File: SF16/35917
Job ID: DOC16/395692
Your Ref: DA 445-10-2003 MOD 4

Notification of a section 75W modification request to Sydney Opera House – Use of the Southern Forecourt Monumental Steps for Temporary Events (DA 445-10-2003 MOD 4)

As delegate of the Heritage Council of NSW, I provide the recommended conditions of approval below. Please note that these conditions are in addition to those of the existing consent.

Drawing Number  
OA\_SOH\_TO\_MASTER\_03A

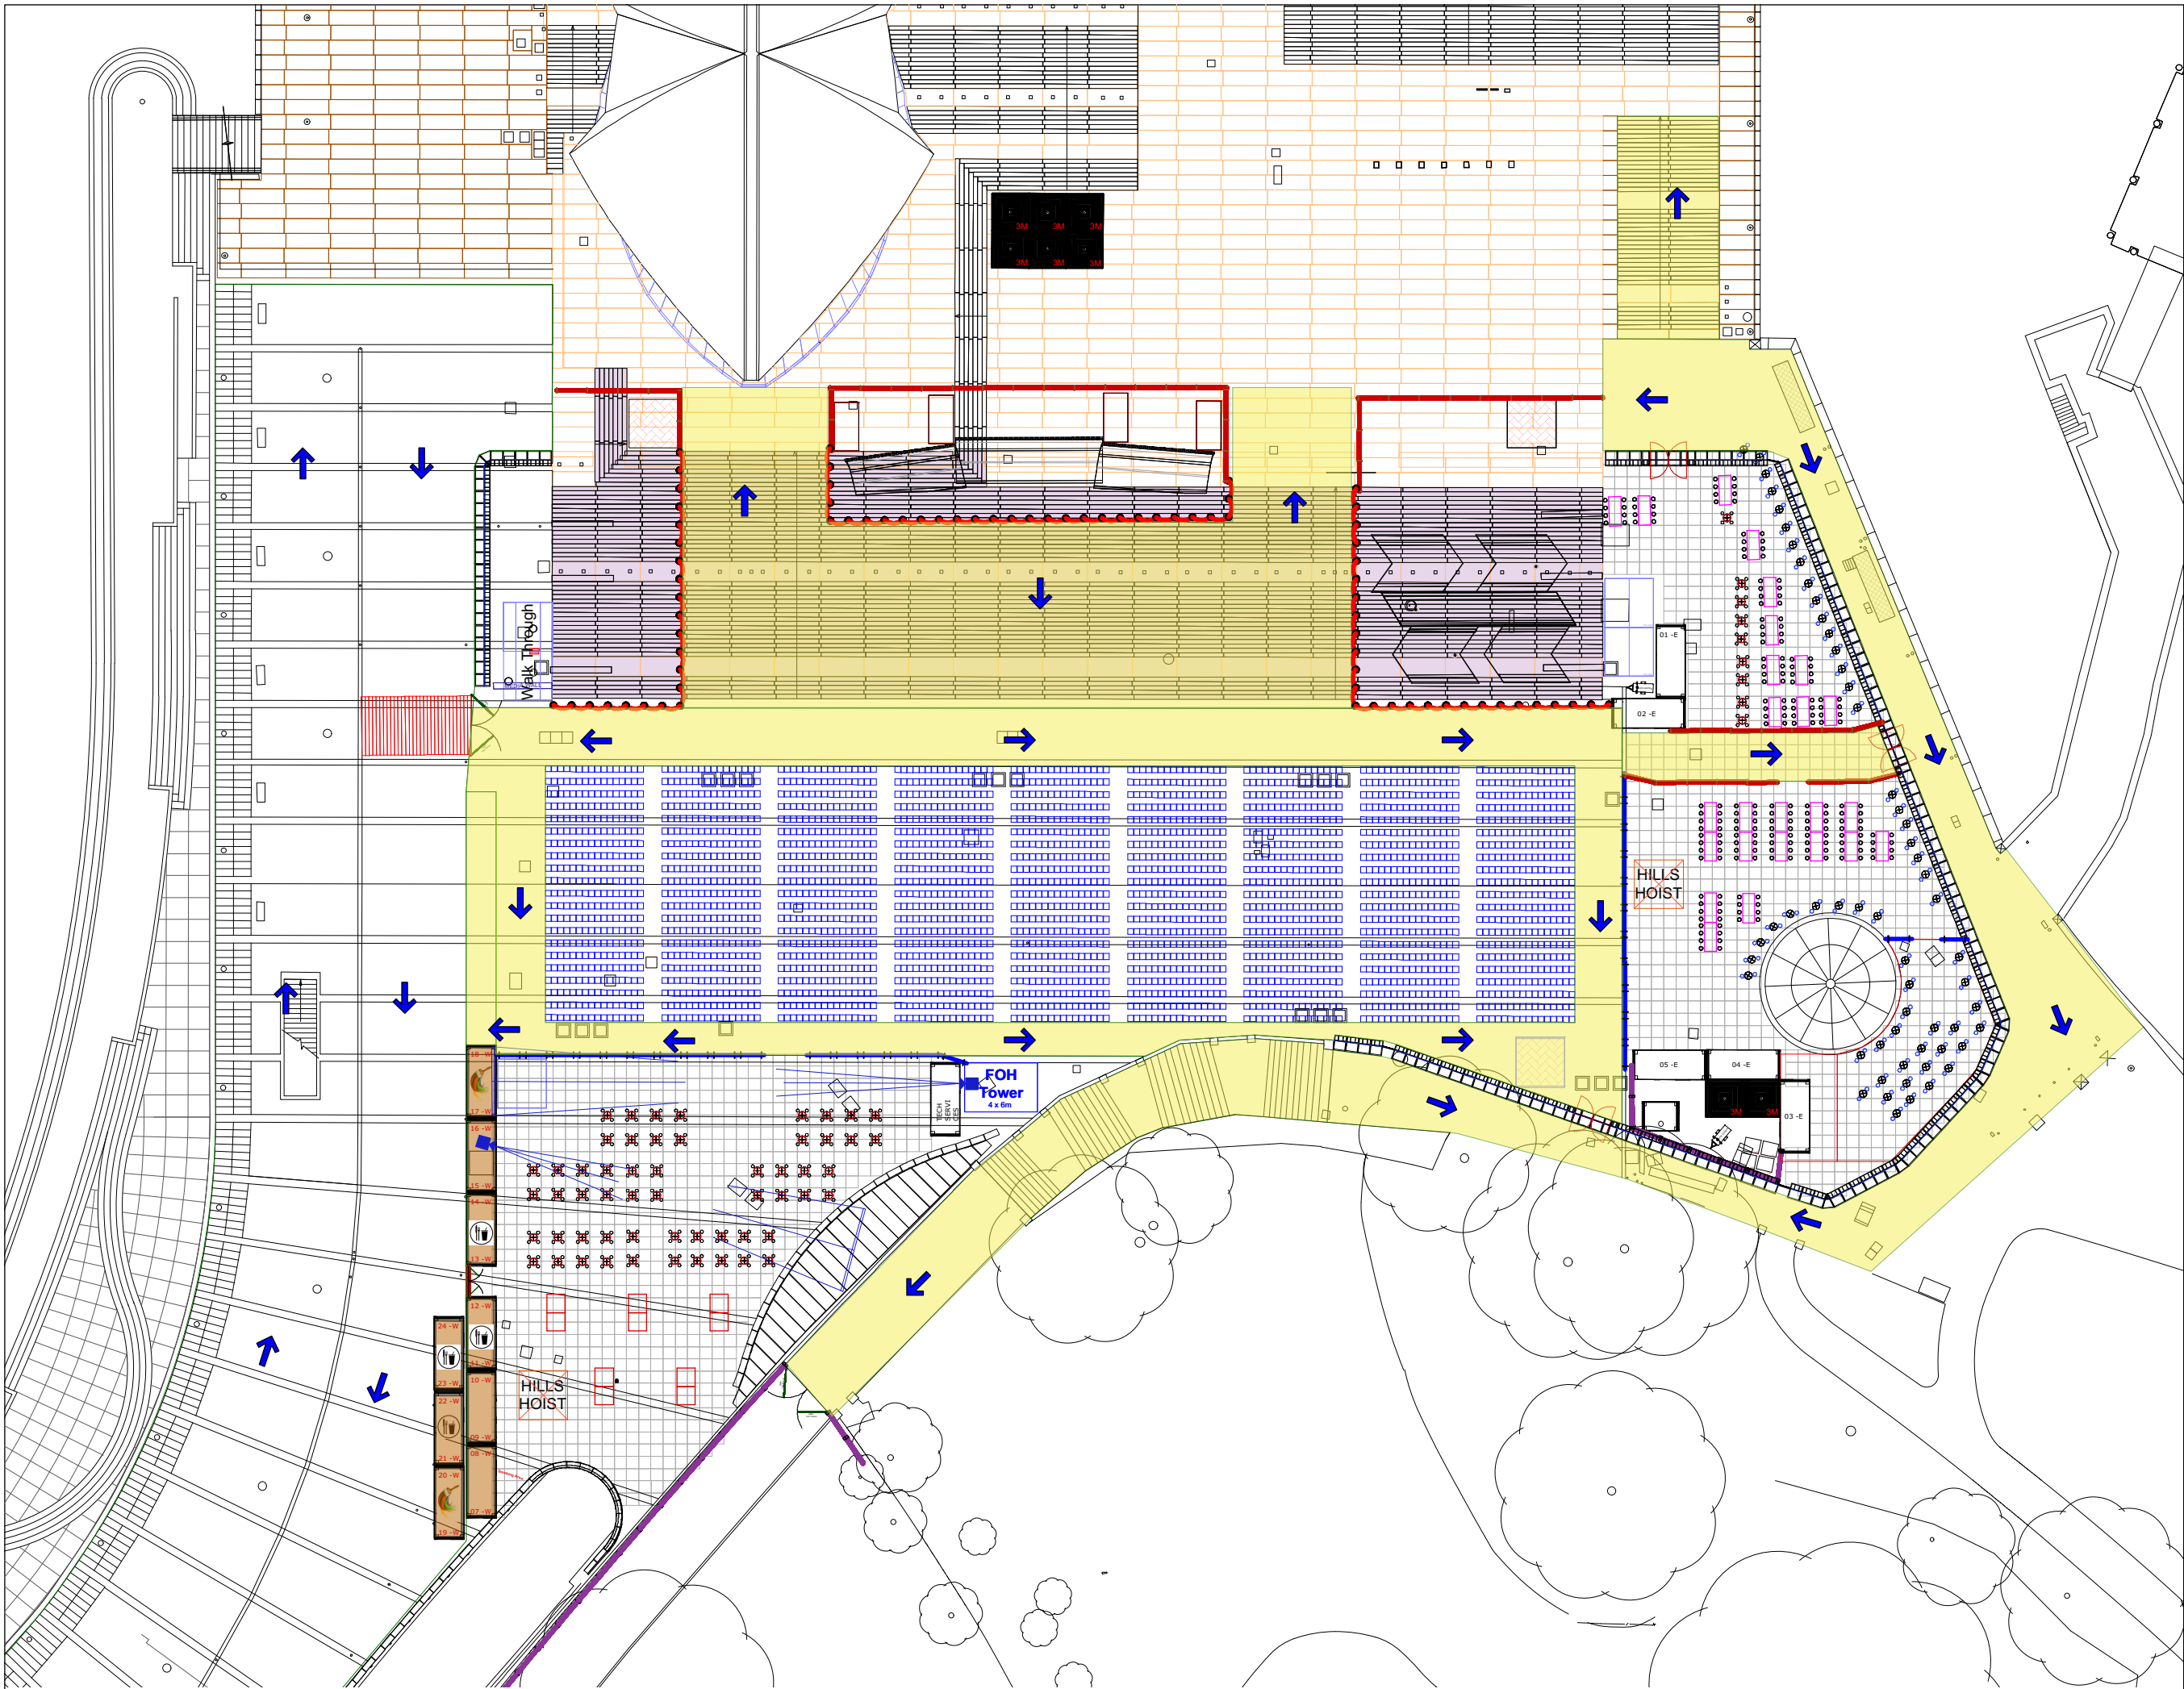
- f) Stage, rear and side-stage trucks and props for the one-off opera event in 2016, when not in use and between blocks of performances should, where possible, be moved to the eastern end of the monumental steps to minimise visual intrusion and to maximise public access to these steps.
